Date: 05 September 2025
Our ref: 27347/523982
Your ref: EN010115

Application by Five Estuaries Offshore Wind Farm Limited (“the Applicant”) for an Order granting Development Consent for the proposed Five Estuaries Offshore Wind Farm (“Project”)

On 11 July 2025, the Secretary of State (SoS) requested information from specific parties. On 14 August 2025, the SoS invited all Interested Parties (IPs) to comment on the responses received to the previous Request for Information (RFI). The following, therefore, constitutes Natural England’s formal statutory response to SoS’s second RFI (‘RFI2’) dated 14 August 2025. Please note that this response provides detailed information that supports our response to questions in the SoS’s RFI 3 (dated 21 August 2025).

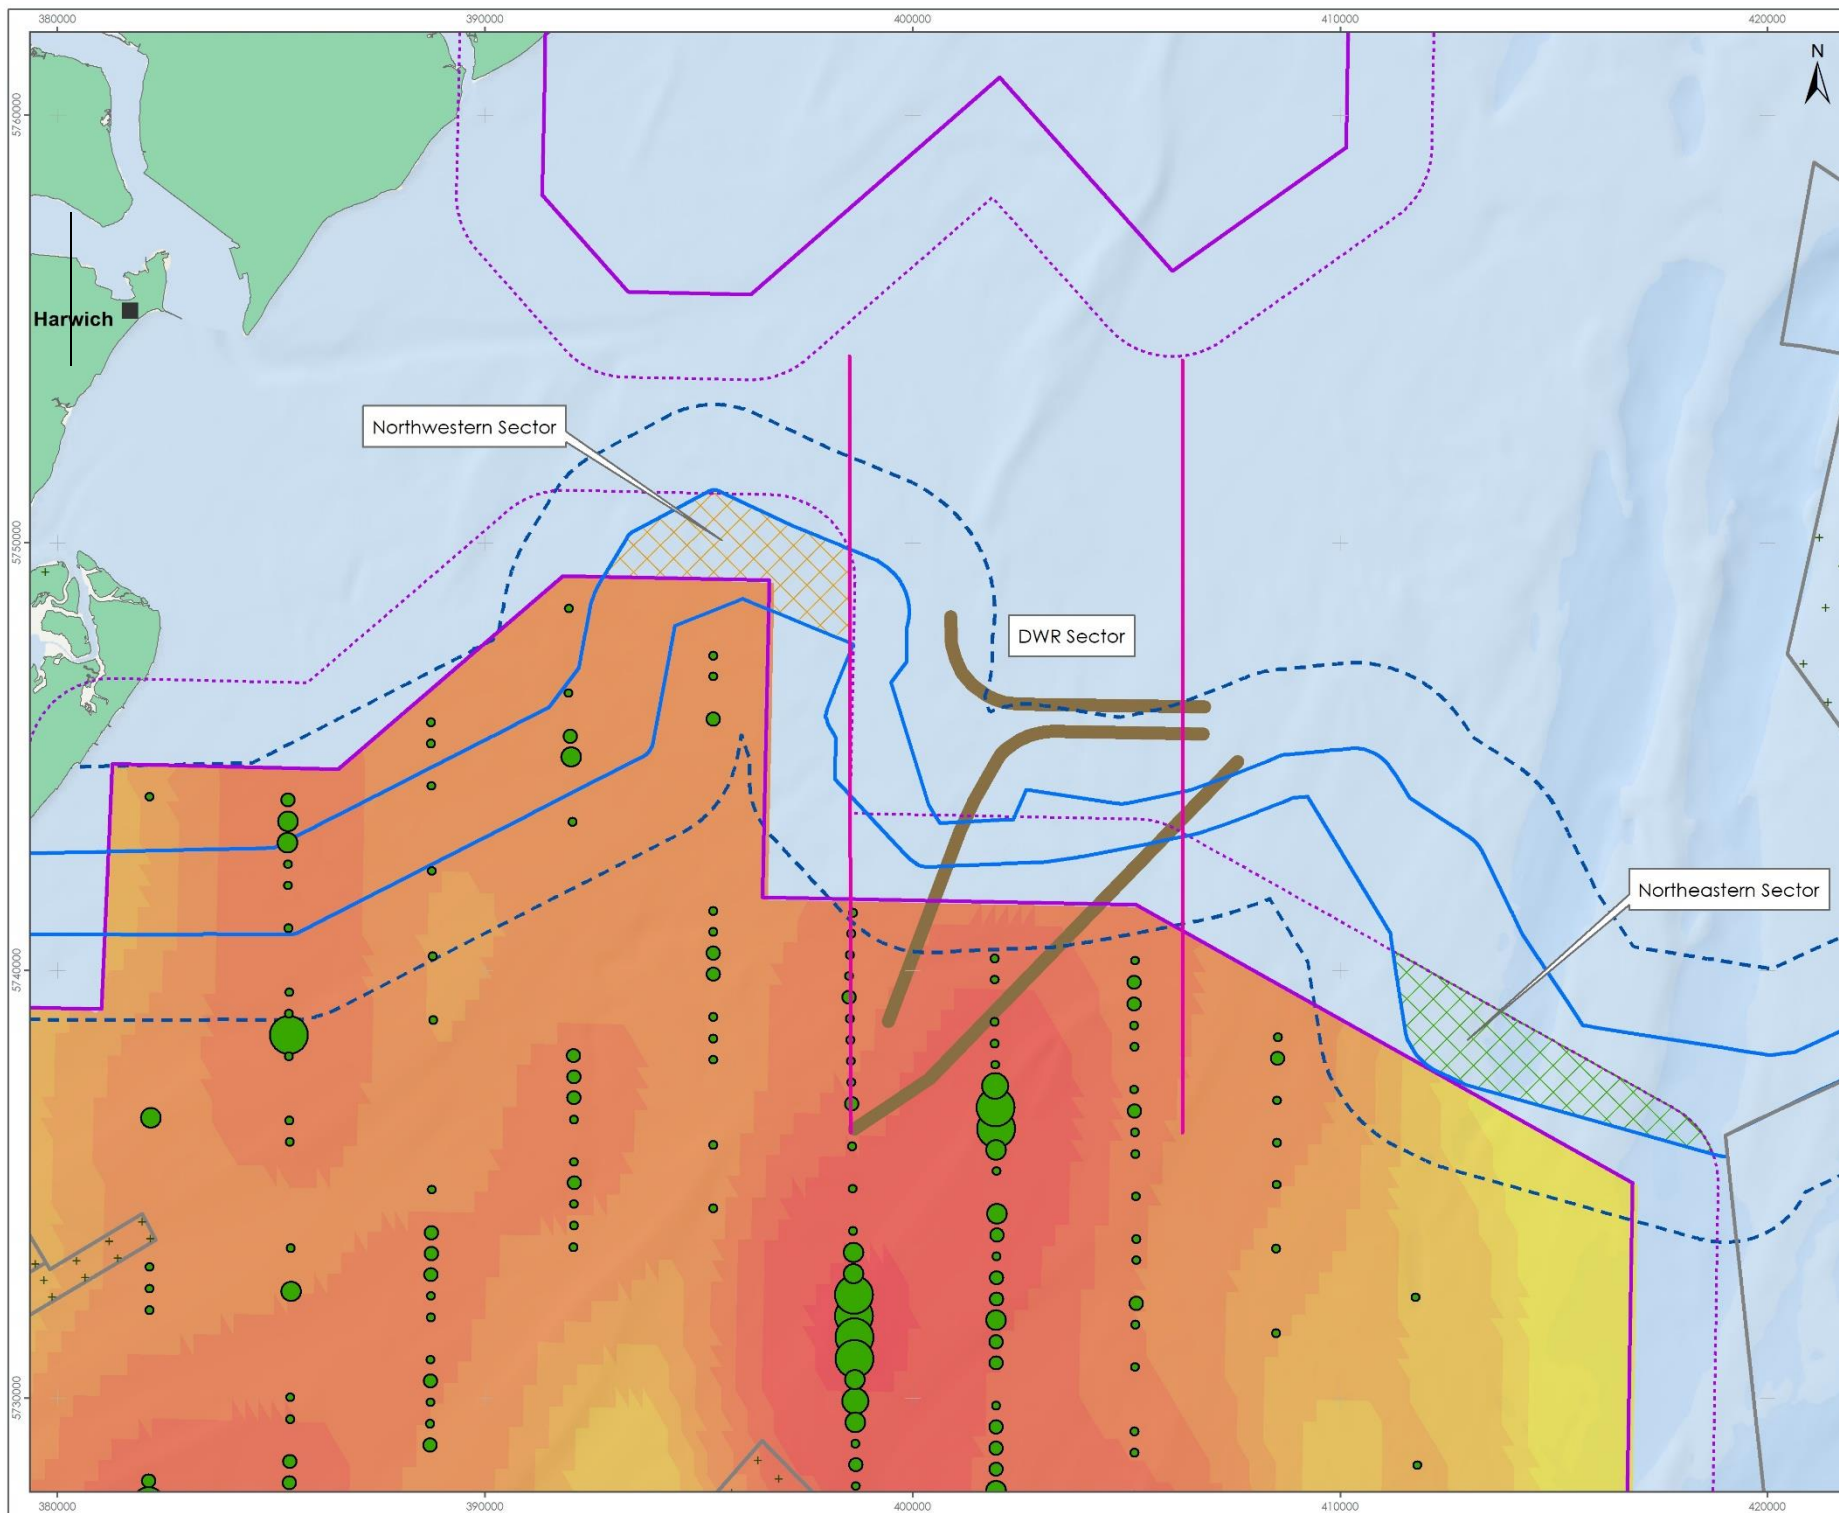
Ltd - Responses to Part 2 - Working in Proximity to Wildlife in a Marine Environment (Tracked) (Rev C)			
NE Ref	Section	Key Concern and/or Update	Natural England's Advice to Resolve Issue
1	Sections 3.3.3-3.3.10, fig. 3.1	Natural England welcomes the illustration of RTD distribution in relation to the Margate and Long Sands Sandbank. We acknowledge that it provides evidence to explain where the highest numbers of RTD occur in relation to the SPA border. However, we highlight the distribution data presented by the Applicant represents just one of the two surveys reported by Irwin et al. 2019. If both DAS data are examined, high/medium densities of RTD can be seen not only associated with the sandbanks but also at points closer to the northern SPA boundary. Moreover, the distribution reported by Irwin et al. 2019 only considers DAS from two dates in February 2018 and these show variation between surveys, therefore, precaution should be applied to their interpretation and representation of the RTD SPA distribution across the whole period. It is important any activity undertaken within the buffer does not erode habitat availability in the SPA's outer limits and therefore reduce its ability to support the qualifying feature.	Given the limitations in the available data for RTD distribution in the SPA, we remain concerns about potential impacts to birds in the SPA from vessel activity inside its 2km buffer. Therefore, as stated above, we advise that further work will be needed in the post-consent phase to provide greater detail and assurance on the schedule and duration of work planned inside the SPA buffer, notably west of the Trinity DWR, before we can conclude no AEol.
